KITTTITAS COUNTY COMMUNITY DEVELOPMENT SERVICES

November 29, 2021

Subject: Stanavich (LP-21-00003) Preliminary Agricultural Plat - Staff Review and Request for Additional Information

STANAVICH AG PLAT  
PART OF SECTION 35, T. 19 N., R. 18 E., W.M.  
KITITAS COUNTY, WASHINGTON  
- PRELIMINARY PLAT -

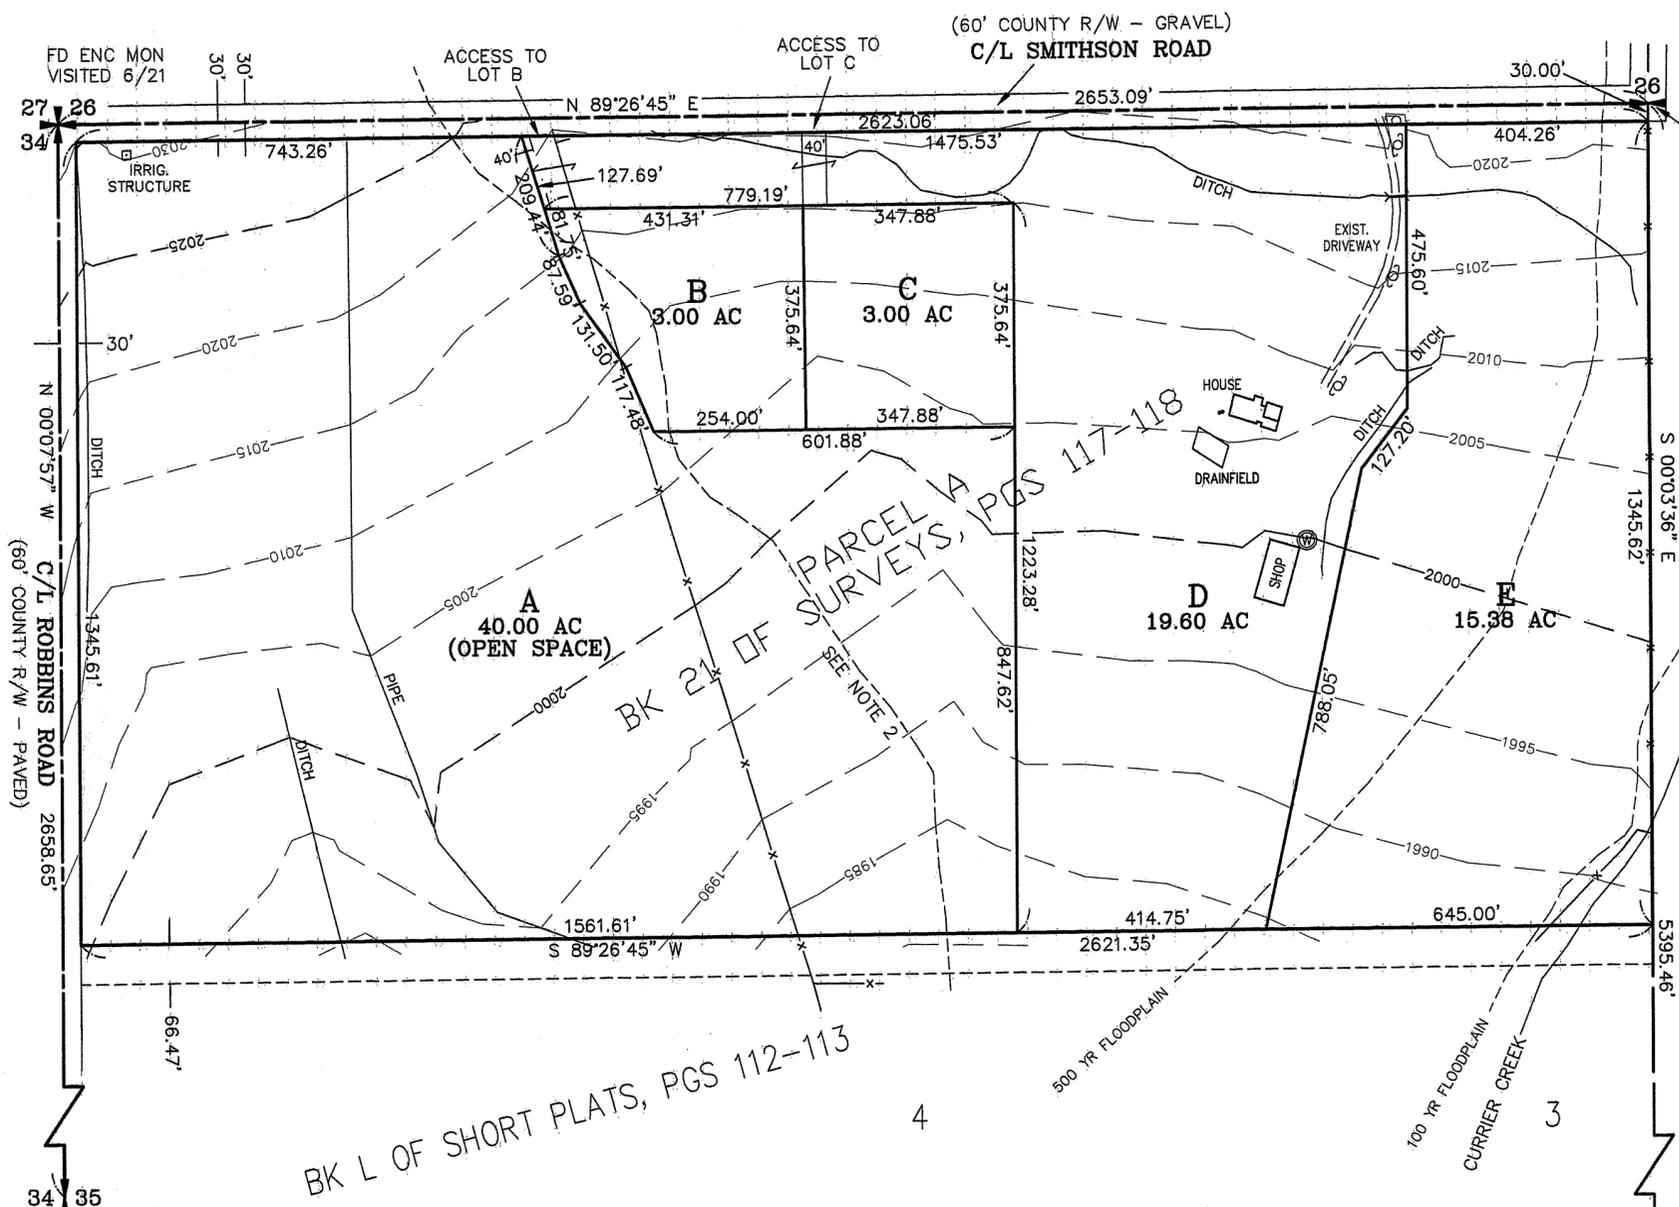
- In their comment letter dated November 3, 2021, the Washington State Department of Ecology (WSDOE) raised concerns regarding wetlands occurring on the property and the subdivision of the land creating parcels for future development that may impact potential wetland and buffer habitats. A critical areas study which addresses the concerns noted by WSDOE in this comment letter will need to be addressed pursuant to WAC 197-11-335 (1) through a critical areas study of the proposed subdivision areas. CDS will require a study that addresses the environmental issues noted by WSDOE and adequate time to review this study prior to issuance of a SEPA determination.
